EL PASO COUNTY STORMWATER MANAGEMENT PLAN CHECKLIST

EPC Project Number: PPR-2245

GRADING AND EROSION CONTROL PLAN

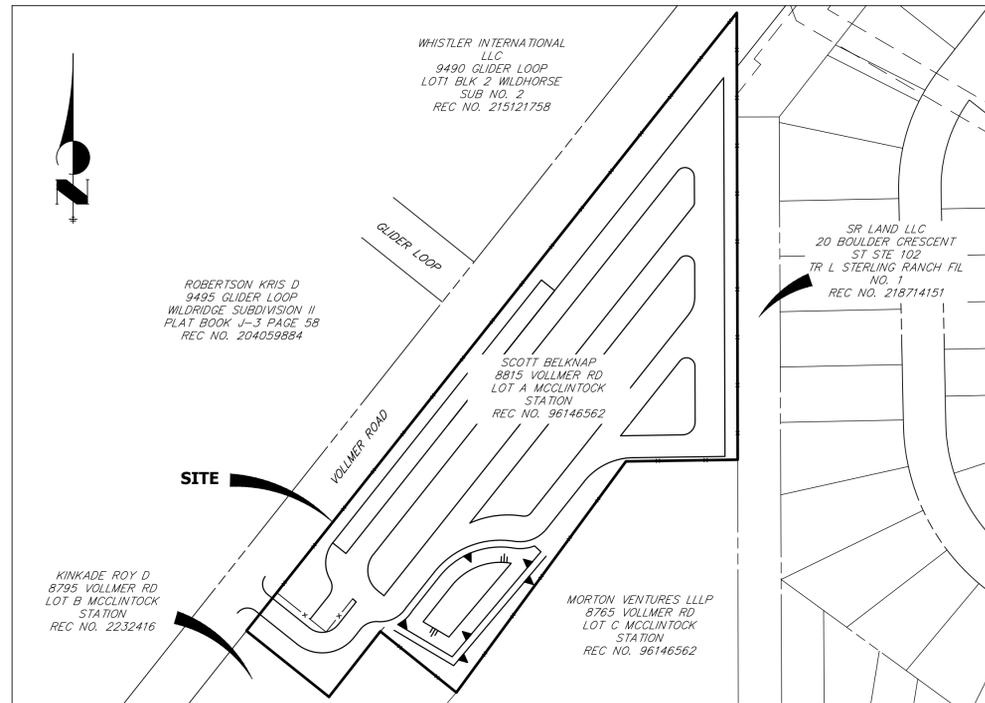
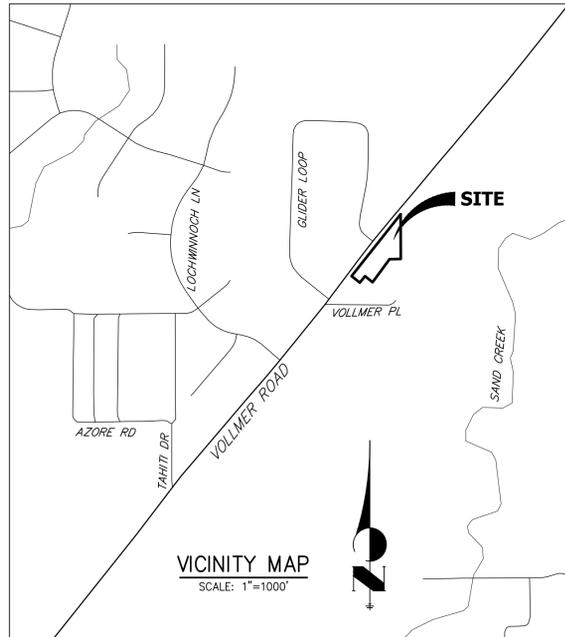
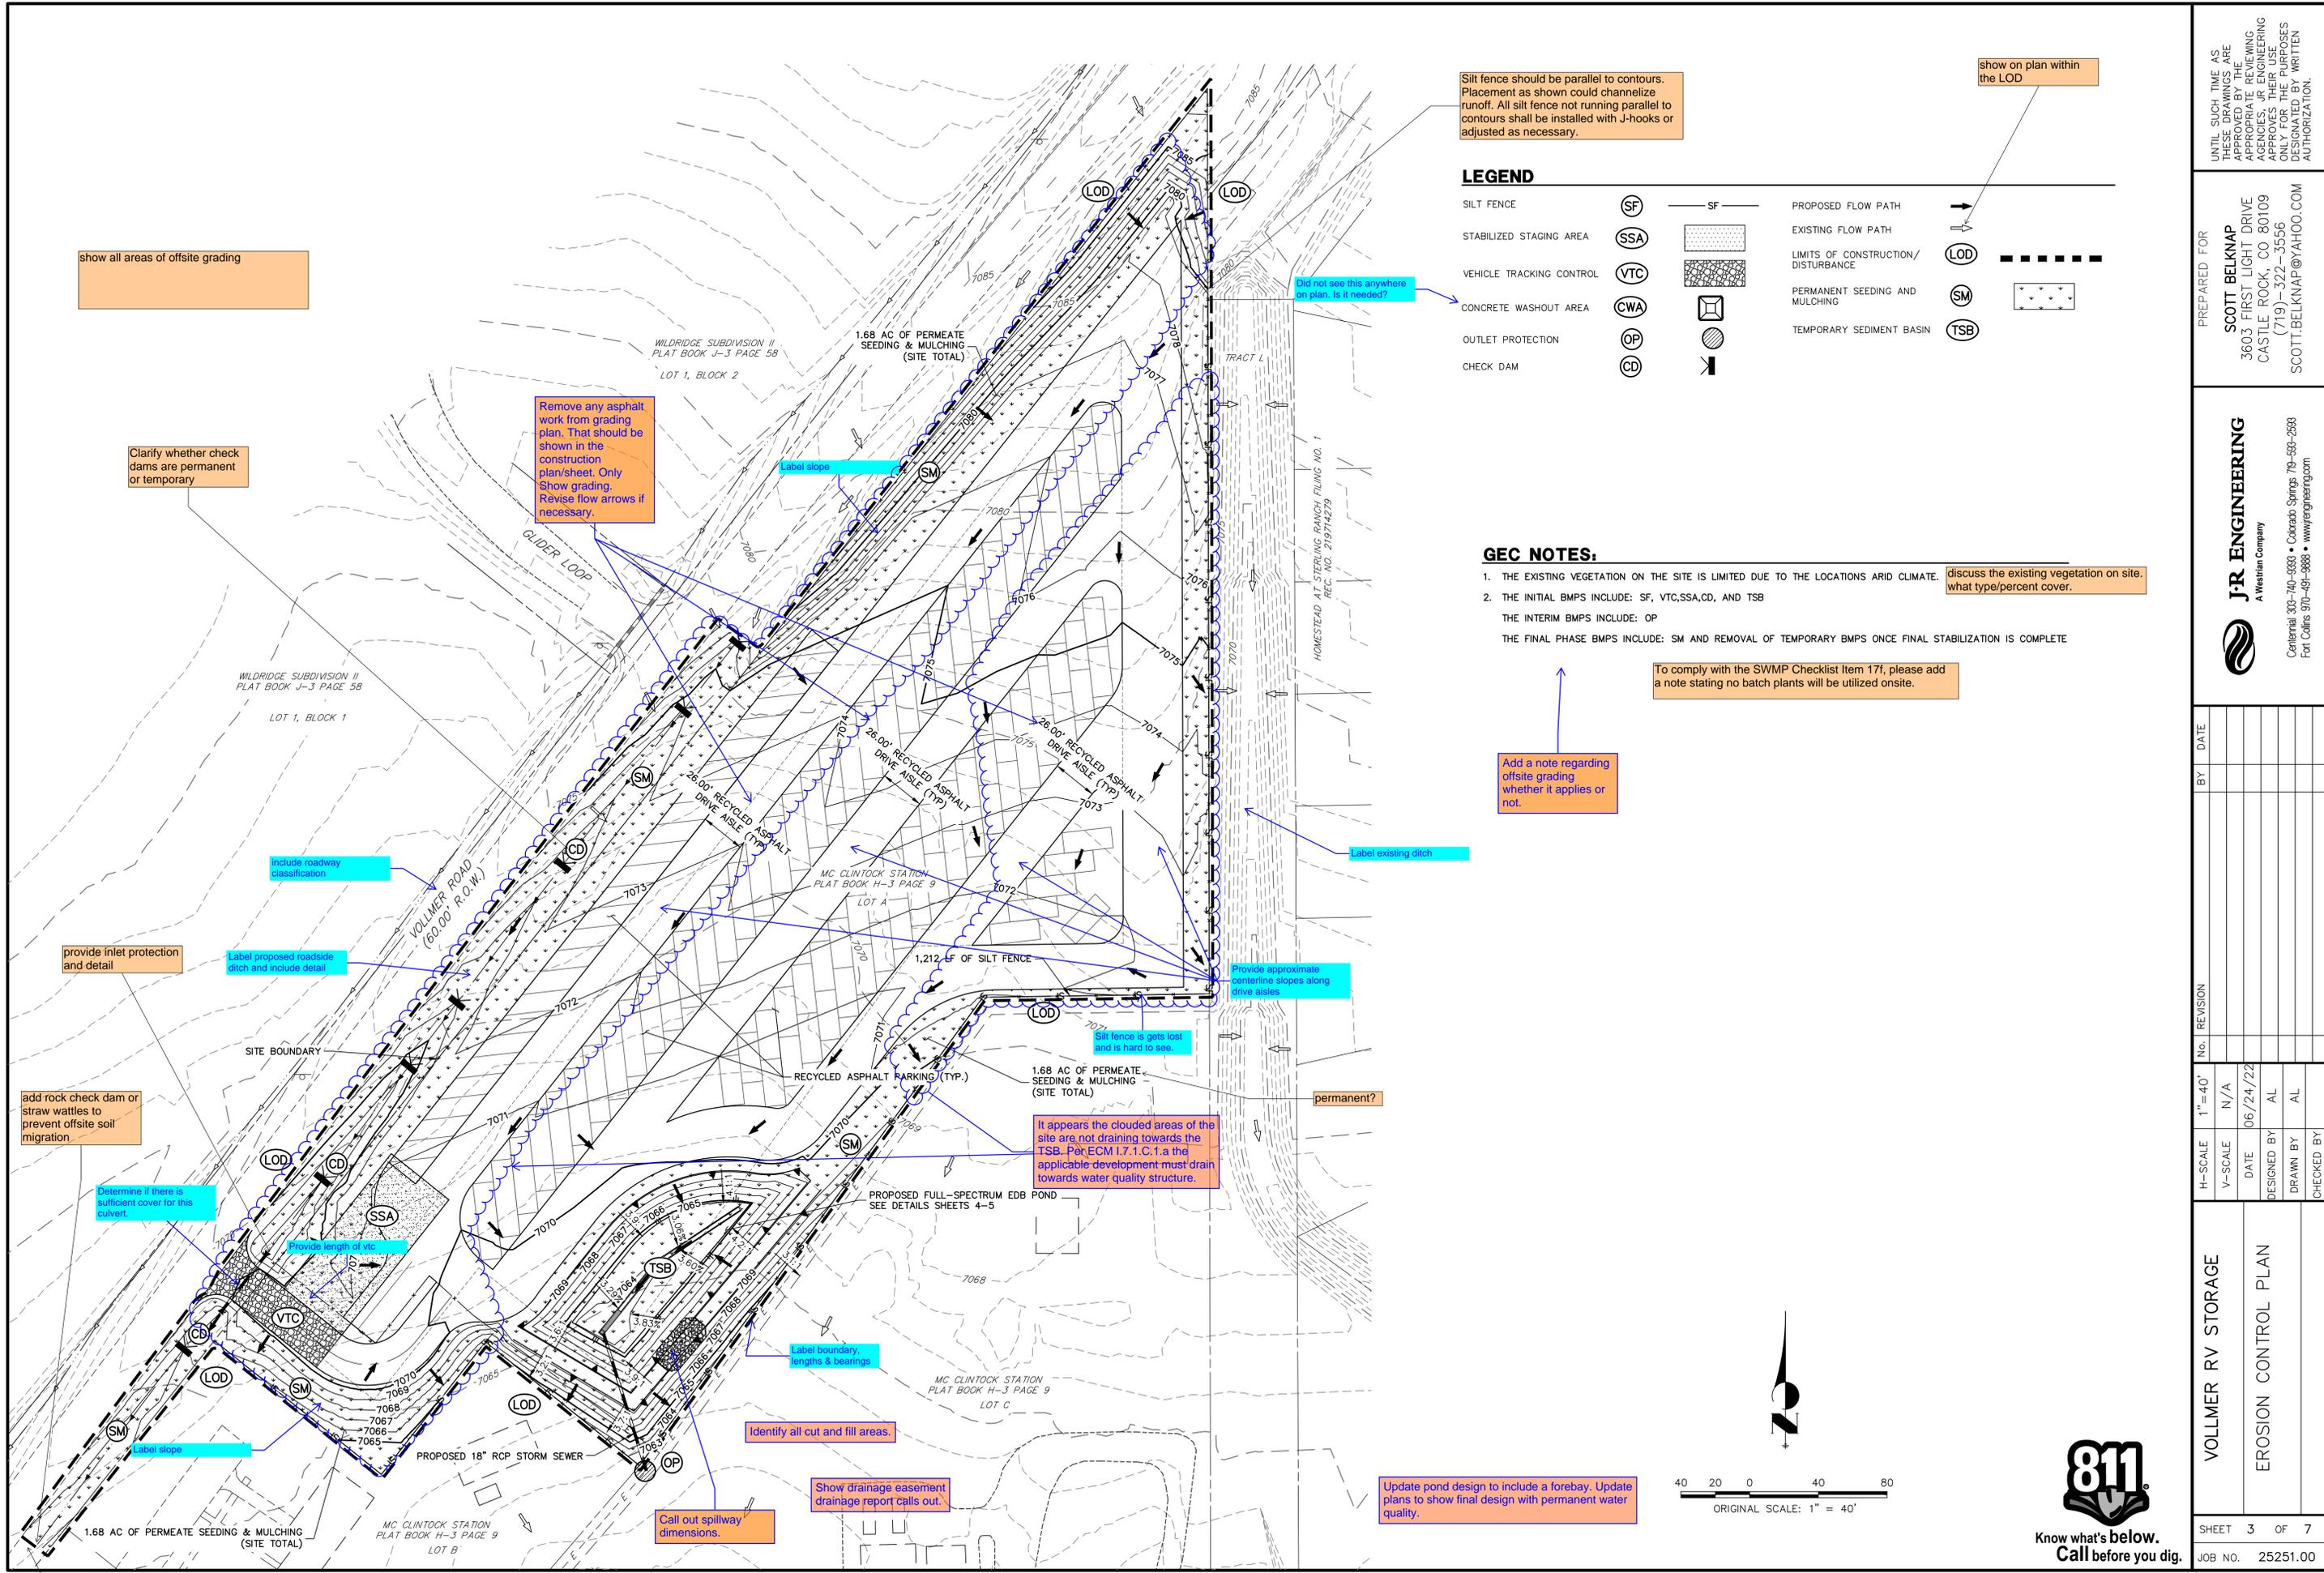
Show areas of cut and fill.

Applicant	EPC
17	SWMP Map to include:		
17a	construction site boundaries		✓
17b	flow arrows to depict stormwater flow directions		✓
17c	all areas of disturbance		✓
17d	areas of cut and fill		✗
17e	areas used for storage of building materials, soils (stockpiles) or wastes		✓
17f	location of any dedicated asphalt / concrete batch plants		✗
17g	location of all structural control measures		✓
17h	location of all non-structural control measures		✓
17i	springs, streams, wetlands and other surface waters, including areas that require maintenance of pre-existing vegetation within 50 feet of a receiving water		✓
18	Narrative description of all structural control measures to be used. Modifications to EPC standard control measures must meet or exceed County-approved details		✓
19	Description of all non-structural control measures to be used including seeding, mulching, protection of existing vegetation, site watering, sod placement, etc.		✓
